PROJECT #: 22-1682-B

DATE: September 11, 2023

LOCATION: Lot 28, Prince Place

PLANS REF: Lot 28, Prince Place by Murphy Garnow Design Group Project #: 22-1682

7 of 8

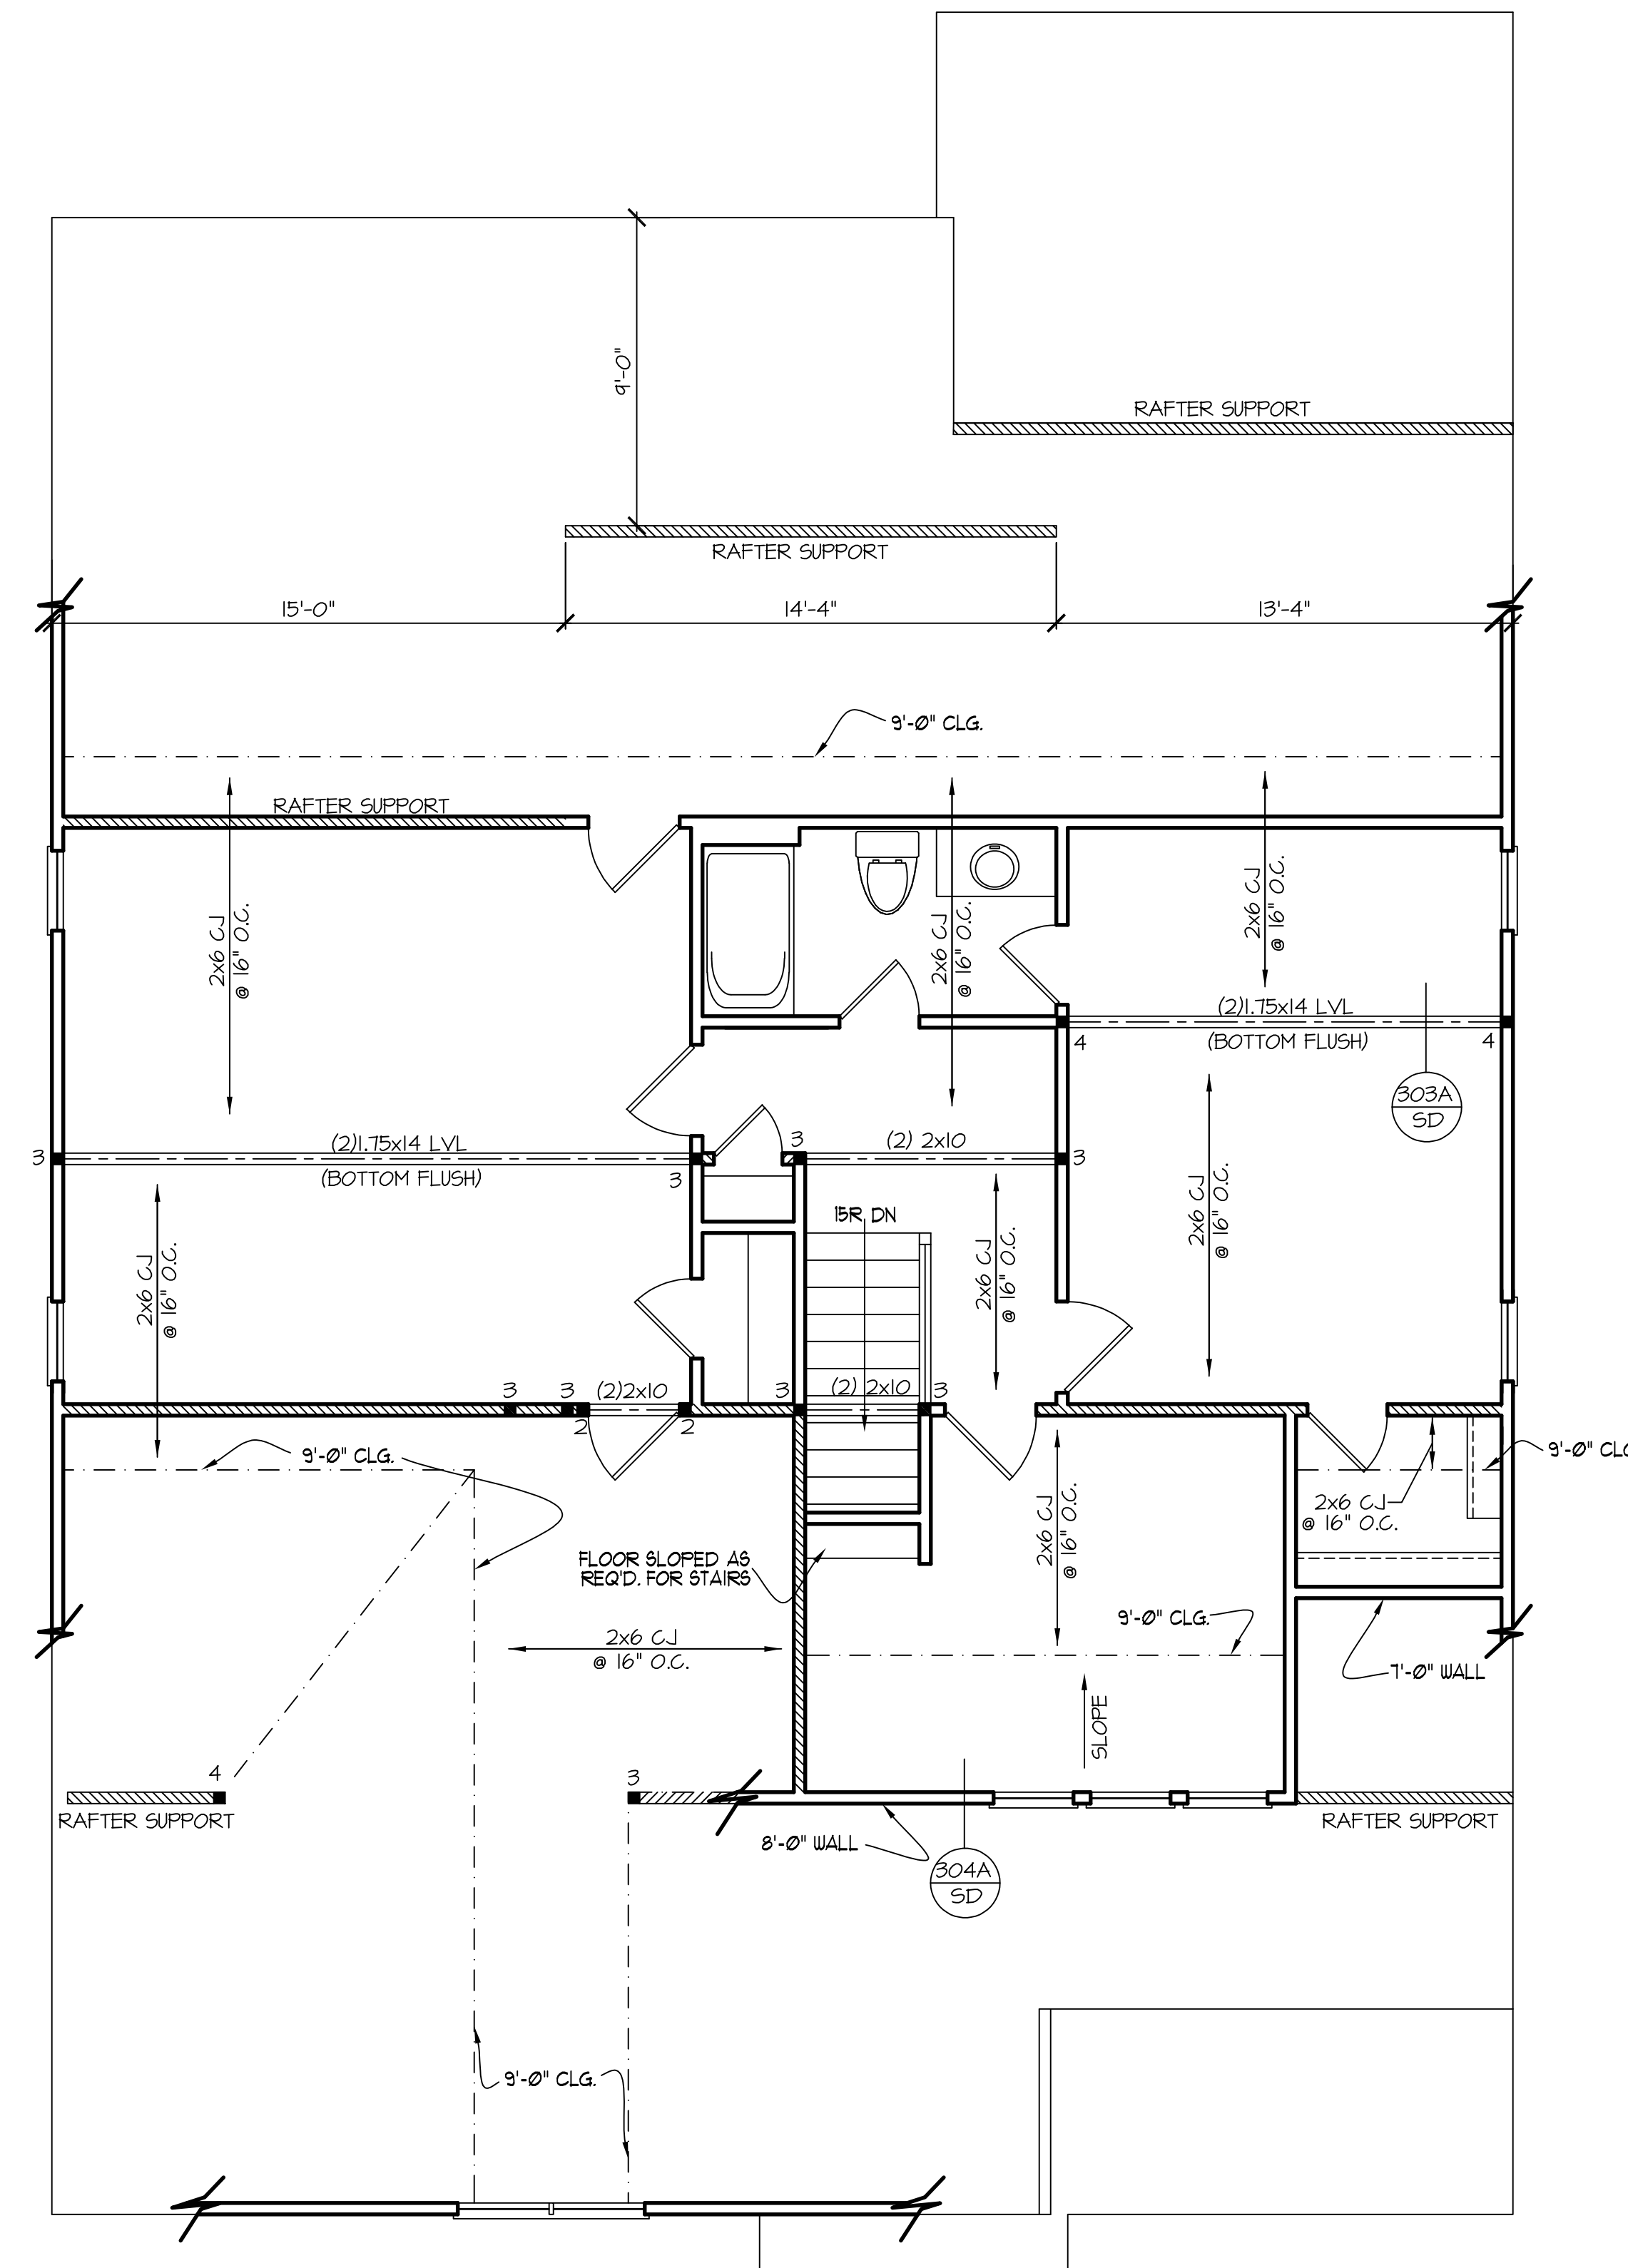
Porch Post Attachment: Page seven of the plans shows porch posts labeled as “4x4 treated post (or equal), see porch post notes”. Please be advised that the connectors listed in the “Porch Post Notes” are recommended connectors only. Alternative connectors that meet the NC Residential Code, any local codes, and/or the building inspector’s interpretation or approval may be substituted.
